Application: SSI 7485

We write regarding the proposed modification to M4-M5 Link, Mod 2 The Crescent overpass and changes to pedestrian infrastructure in North Annandale, Rozelle and Rozelle Bay Foreshore area.

Figure 4-2 Pedestrian and cyclist bridge infrastructure options

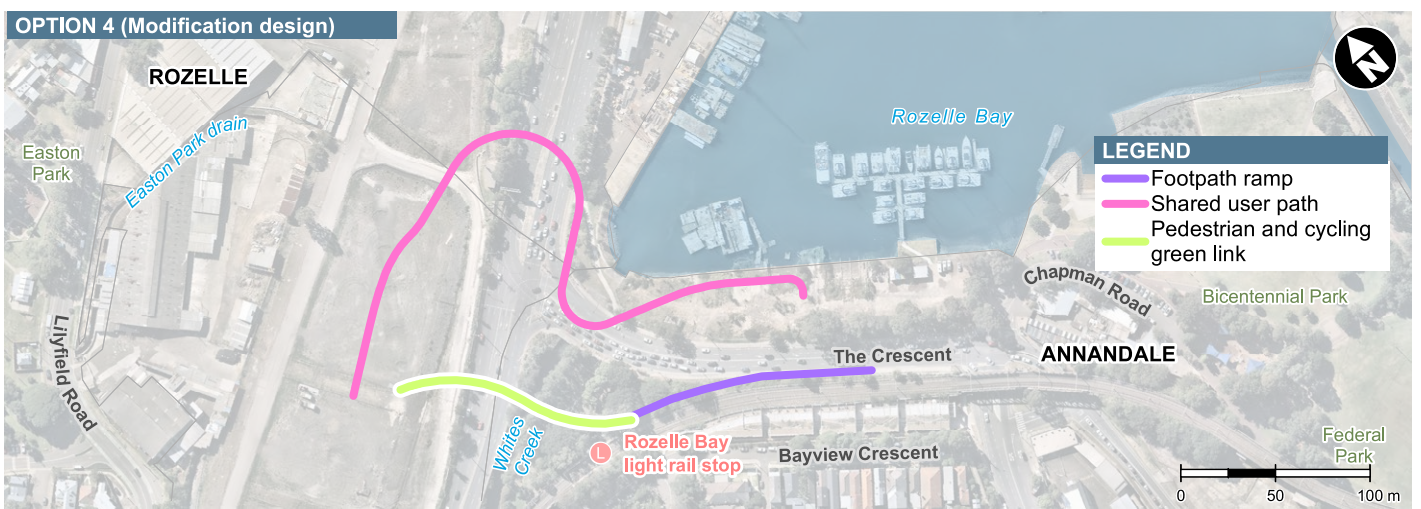
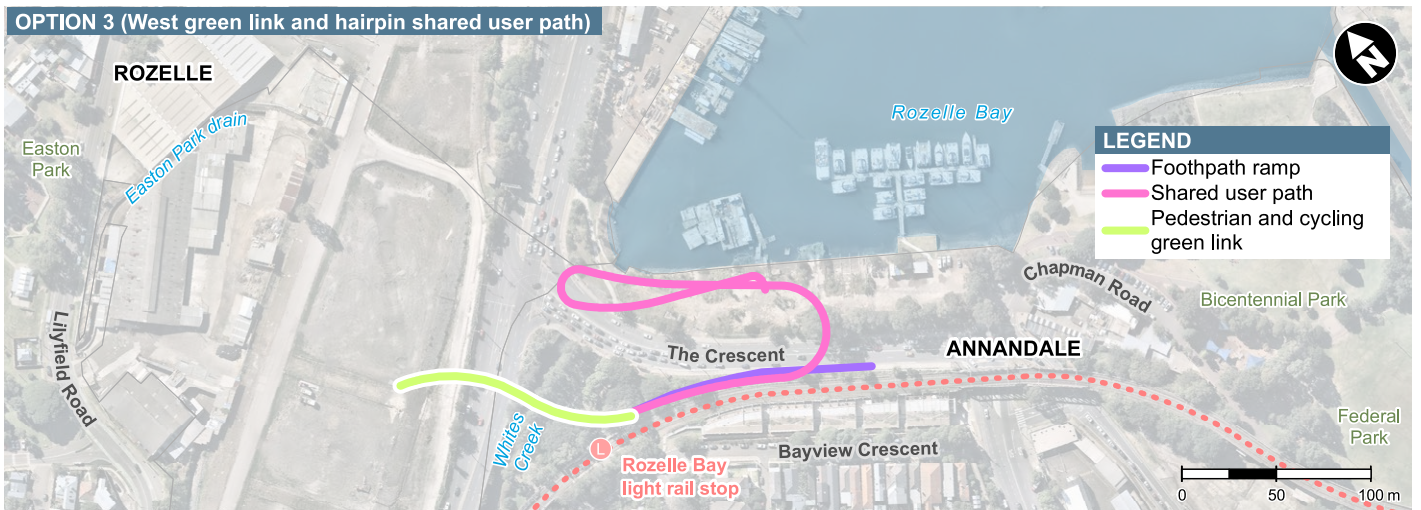
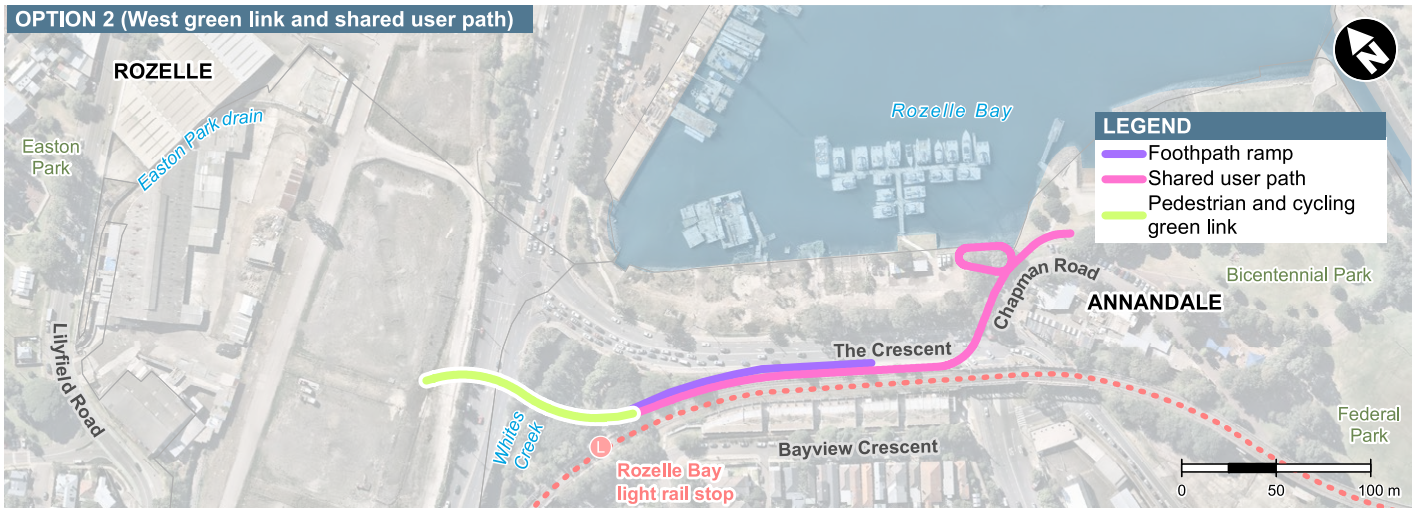
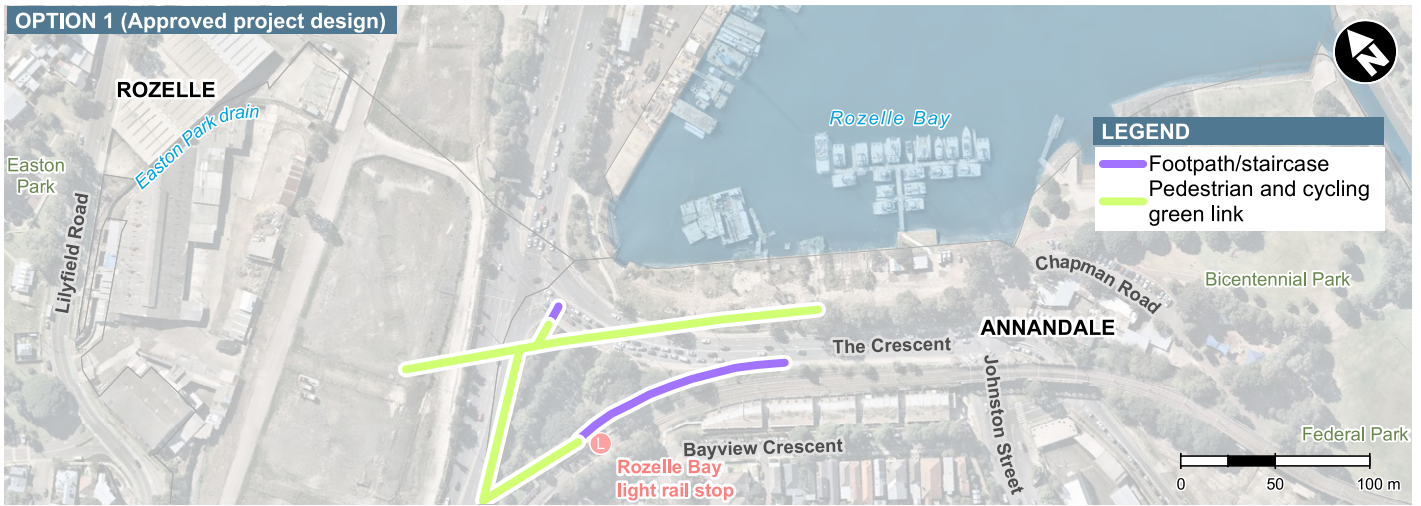
We request RMS work with the community to explore alternate design options to the proposed new car overpass design and the changed pedestrian and cyclist links. We are seeking the reinstatement of the safe, direct access from the approved EIS GreenLink to create a continuous green open space connection from the Rozelle Rail yards and Annandale to the foreshore. The GreenLink was more than just a walk way - it put people central to the design, maximising safety, and providing much needed accessible open space for the community now and into the future Bays Precinct design.

- The significantly reduced safety and increased risk for pedestrians and cyclists with removed access over The Crescent to Bicentennial Park and the increased traffic along Johnson Street.

- Reinstatement of the GreenLink connecting communities and green open space from Rozelle to Bicentennial Park.
- Relocate and design pedestrian and cyclist connections that are continuous, safe

Figure 4-4 Elevation: Indicative view of The Crescent overpass

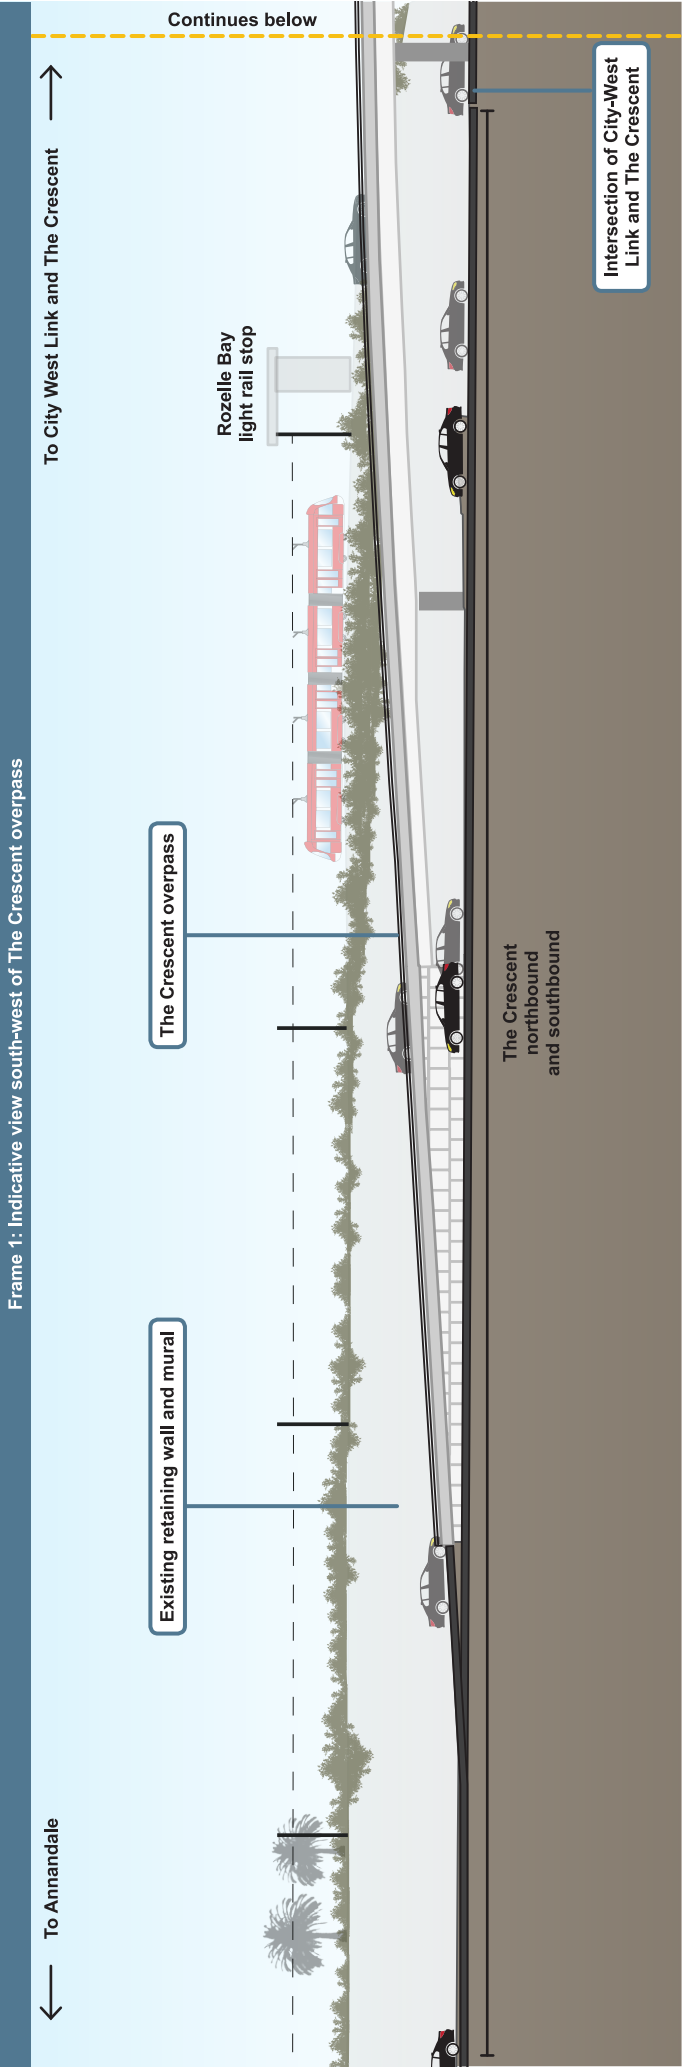
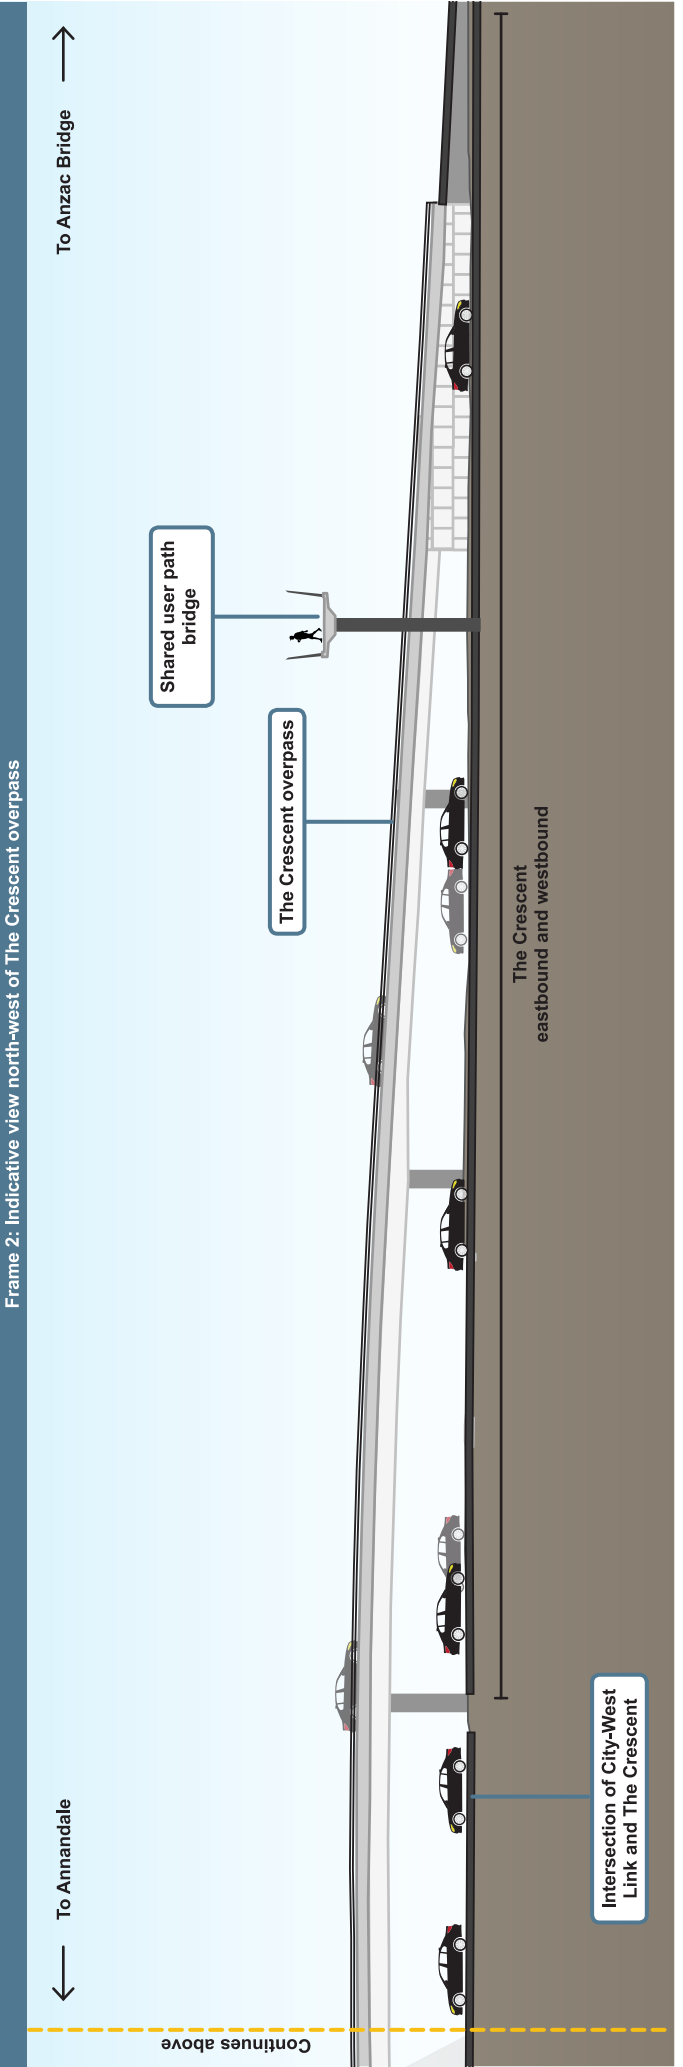
P.S. Please do not approve the construction
of the Crescent Overpass

Figure 4-5 The Crescent/Johnston Street/Chapman Road intersection

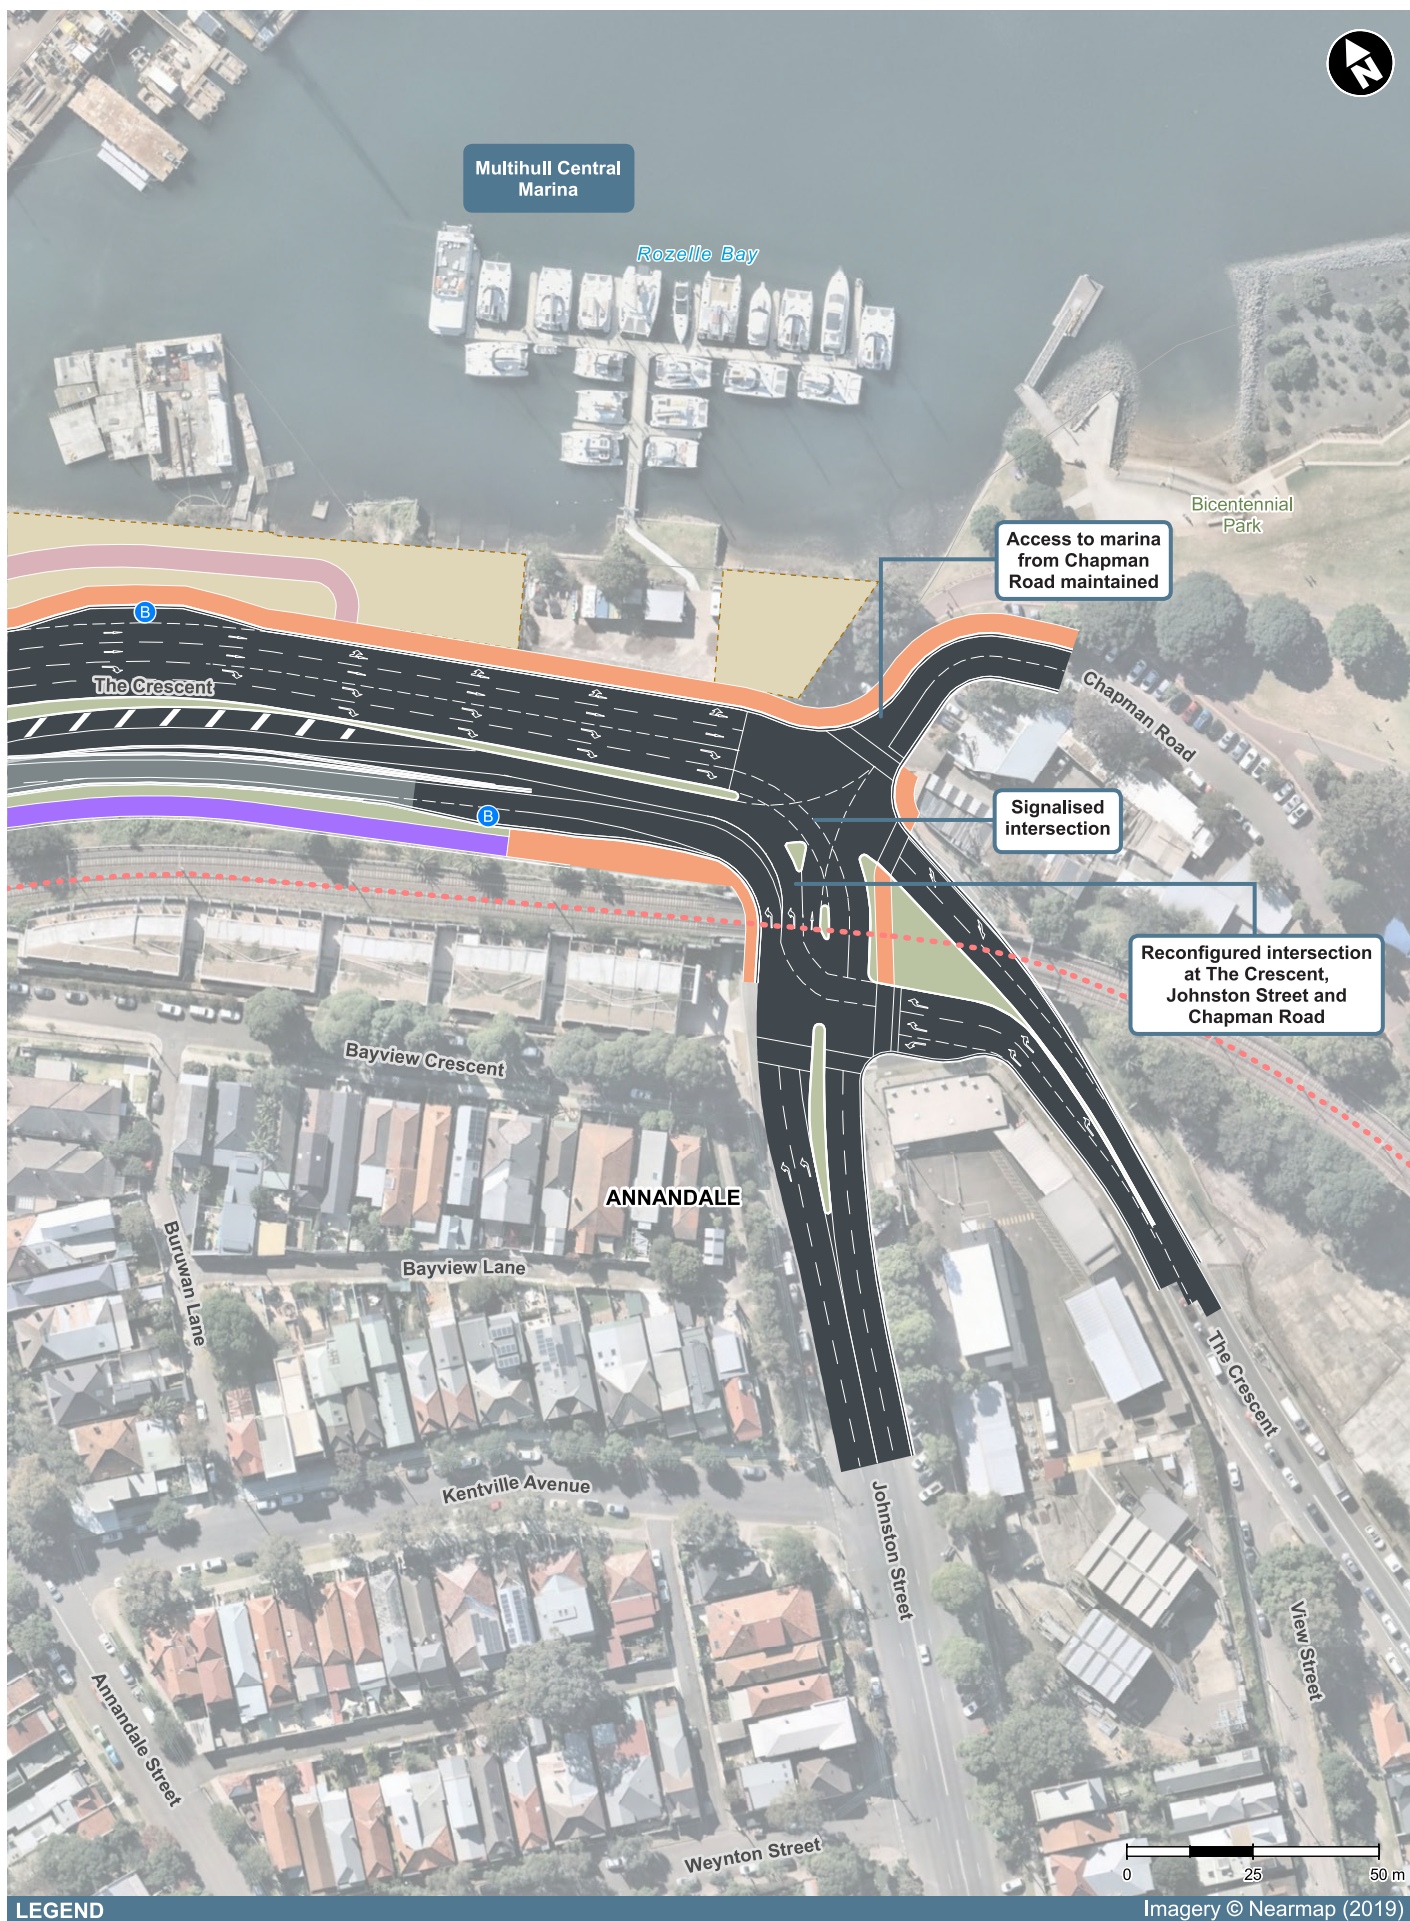
- Being required to cross five sets of pedestrian lights at The Crescent as my option to reach the foreshore from Annandale or from Rozelle light rail stop.

- Urban and landscape design that is being built before a finalised Masterplan for the area.
- Traffic changes that limit movements around the suburb and create further congestion in the local streets of Annandale, Forest Lodge, Glebe, Lilyfield and Rozelle with no planning to deal with these.
